Our Ref: K/17/15/HH

2 Storey side & rear extensions with balconies, conversion of roof void to create En-suite Bedrooms including the insertion of 3no. new dormers, roof alterations, new Garage outbuilding with ancillary accommodation & link to main house & swimming pool.

Russet House Gorse Avenue Kingston Gorse Kingston

Thank you for your internet representation made on 10th June 2015 which has been recorded as '**an objection**' with the comments as follows:

Job Title	
Russet House, Kingston Gorse	
Client	
Miss S Masson	
Drawing Name	
Driveway & Landscaping Plan	
Drawing Status	
Planning	
Drawn by	DF
Date	June 15
Checked by	Date
Drawing Scale	
1:100 at A1	
Drawing No	Status Revision
15753/ 07

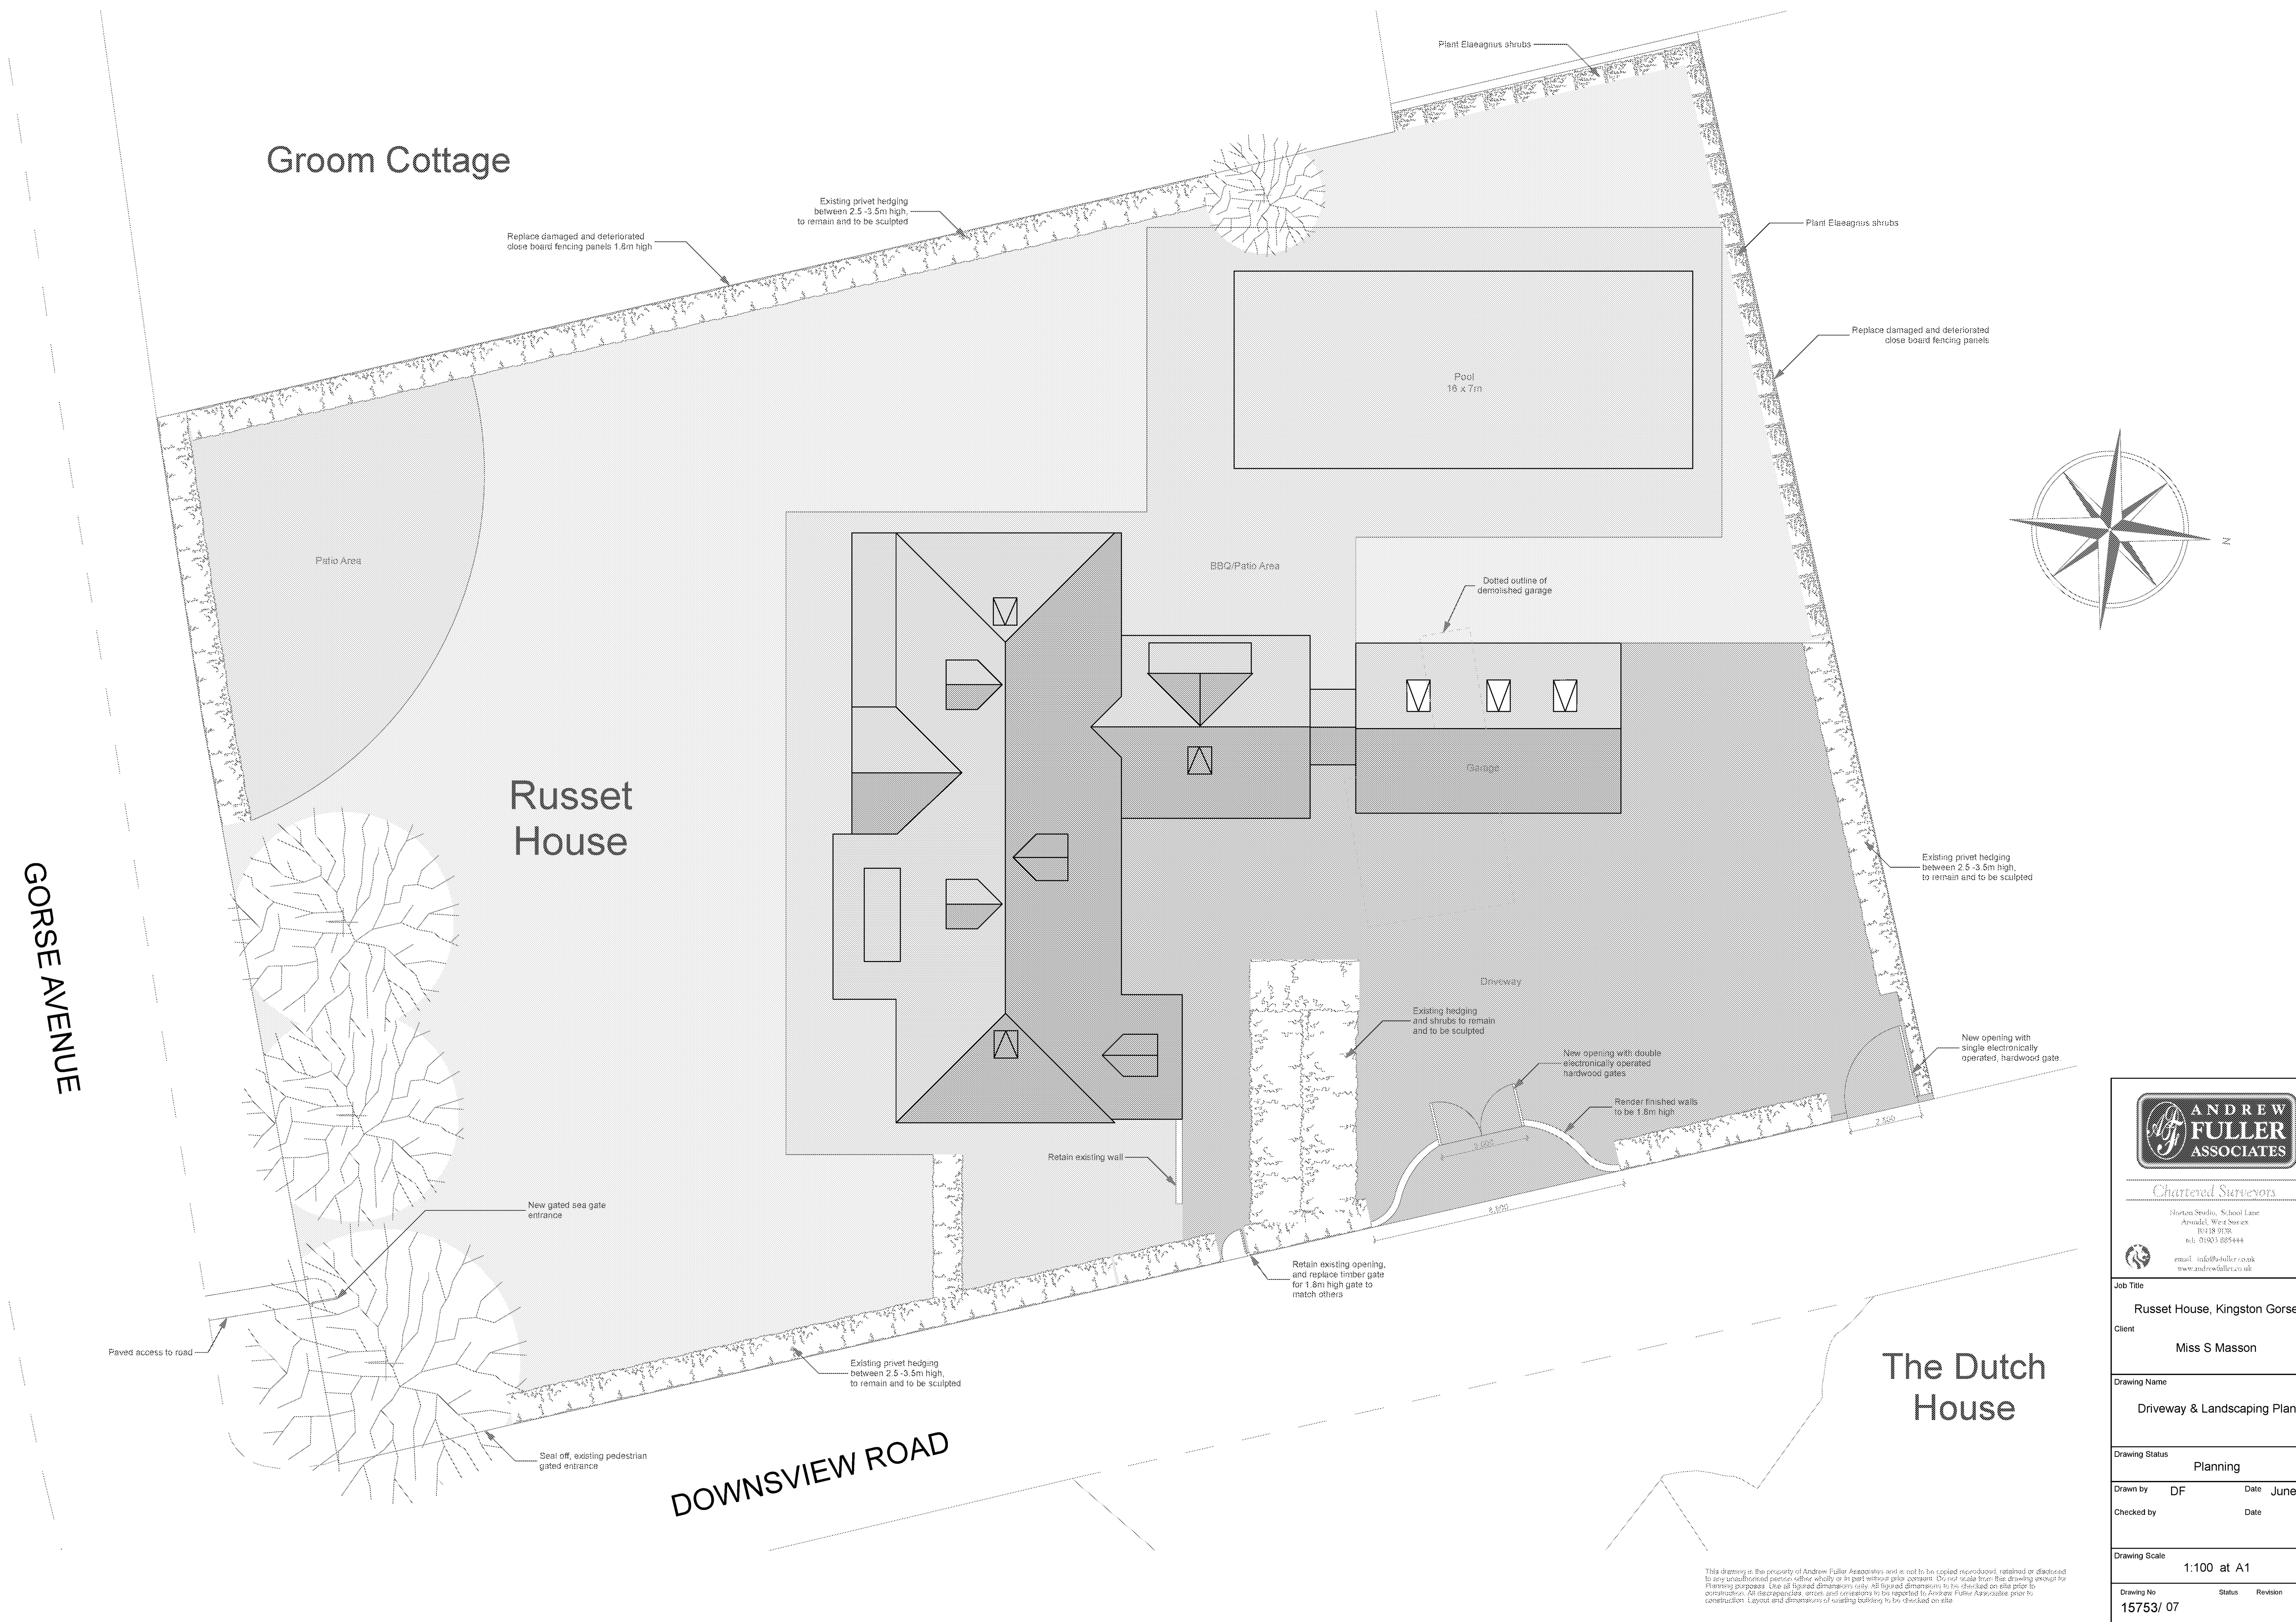
Our only objection is a concern that the introduction of a 3 car garage will substantially increase the size of the driveway opening onto Downsview Road which is a narrow road and unsuitable for such a large driveway opening. We note that the Kingston Gorse Estate has impliedly accepted that the opening will be widened. The plans do not show whether that is intended. If it is not, we have no objection, but we join with other neighbours in asking for a traffic management plan - Downsview Road is too narrow for parking and parking of private vehicles in the road thus blocking access has already been an issue.
Yours faithfully Sarah & James Bridgwater
